The purpose of this letter is to address the Fire Department requirements as listed on the Department of Permitting and Inspections form for Change of Use.

Memo Report

From: W. Mark Cummings, P.E.
To: Mr. Ned Wight; New England Distilling, LLC
CC: Capt. Keith Perone; Fire Prevention Division, Portland Fire Department
Subject: **Fire Hazards Assessment of the New England Distilling Site at 26 Evergreen Dr., Unit B, Portland, ME.**

**FLOOR PLAN**  
1/8" = 1'-0"

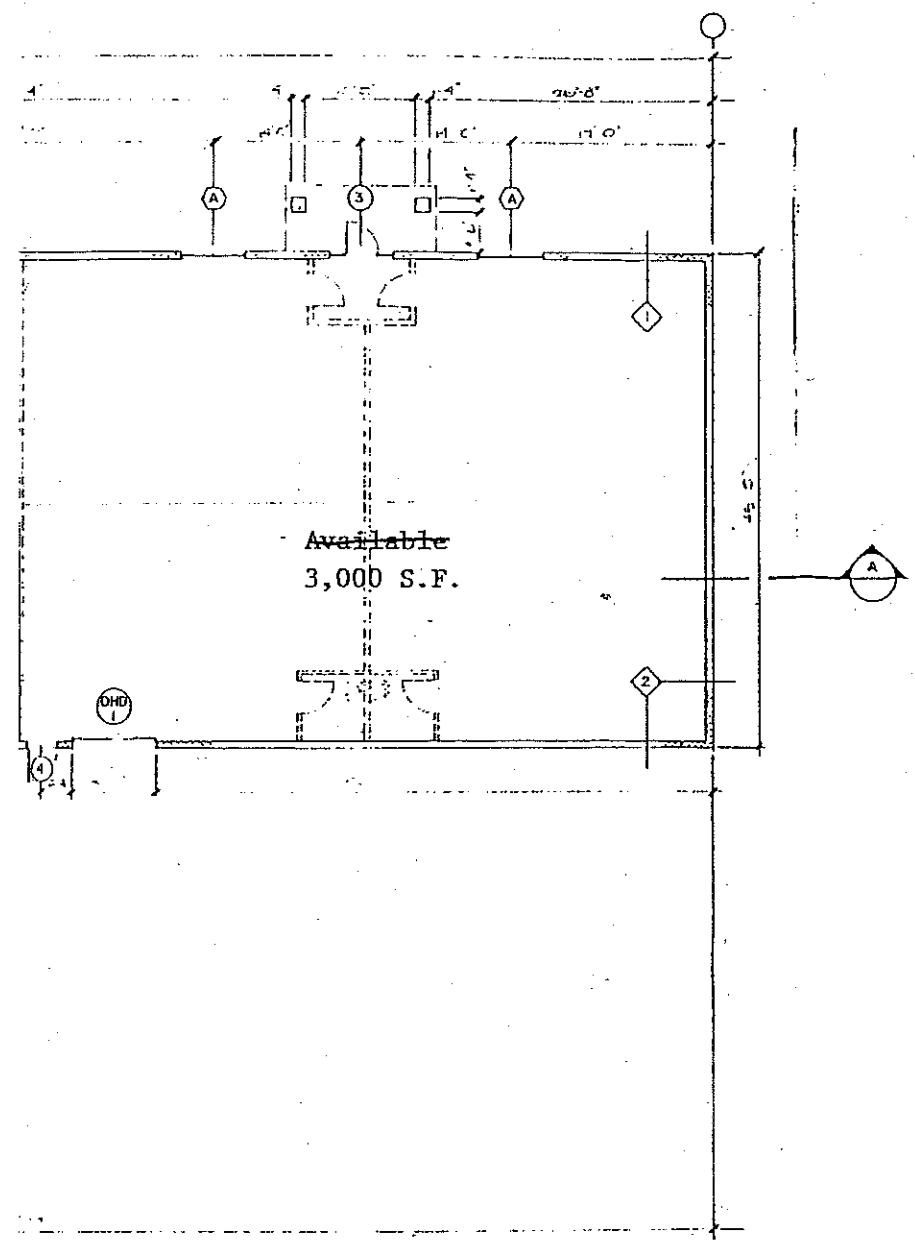
1. Provide an approved exit sign for the door connecting the office and high bay areas. [code requirement]
2. Install a sign that is readily visible and meets the requirements of NFPA 101 (para. 7.2.1.5.4.1), along with all other code requirements, in the vicinity of the egress doors from the high bay area. [code requirement]

3. Provide an installed fire detection/notification system. Based on the requirements within NFPA 30 for "processing facilities", this system is needed to provide early warning to occupants of the building, not just New England Distilling employees. Equally, given that no fire suppression is installed within this building, this system will provide early notification to the responding Fire Department; either directly or via a central monitoring station. Since a security system is already scheduled to be installed and monitored by a third party, the fire detection/notification could also be monitored by the same entity. Given that the greatest risk to both the building and responding firefighters will be a fire occurring when the facility is not occupied, coupled with the storage of flammable liquids on site, early notification will significantly improve the fire safety of this facility. [code requirement]

4. Provide a means for emergency disconnect (closure) of the natural gas fuel supply system. It is recommended that the ability to remotely shut off the fuel supply to the still's heating element be provided to ensure that if a problem occurs with the still's operation, access to shut off the fuel supply will be readily accessible. A remote

manual shutoff (pull station) located by the exit from the high bay area is recommended. Although the code (NFPA 54) does include a requirement [*code requirement*] for such a shut off device, it does not specifically mandate the type or location.

5. Provide a mechanical ventilation system within the high bay area. [*code requirement*] This system is needed to ensure no accumulation of potentially flammable vapors can occur, which could then present a fire risk; especially in the vicinity of electrical systems/components. Since the vapors will be heavier than air and would accumulate near the floor, the inlet and exhaust for the ventilation system must be within 12 inches of the floor. Absent of any specific calculations to determine the minimum ventilation rate required for the specific configuration used at the New England Distilling facility, it is recommended that a ventilation rate of at least 2400 cfm be provided. Based on the stated proposed layout for the facility (see attached sketch), it would be recommended that the location for the exhaust inlet air (vent) be located at the northeast corner of the high bay area, with the exhaust fan being in the opposite corner. This would facilitate movement of air “away” from the proposed location for the still (open flame).

6. Given the configuration of the still’s heating element that involves an open flame, it is recommended that no combustible materials be located/stored any closer than 10 feet from the still.
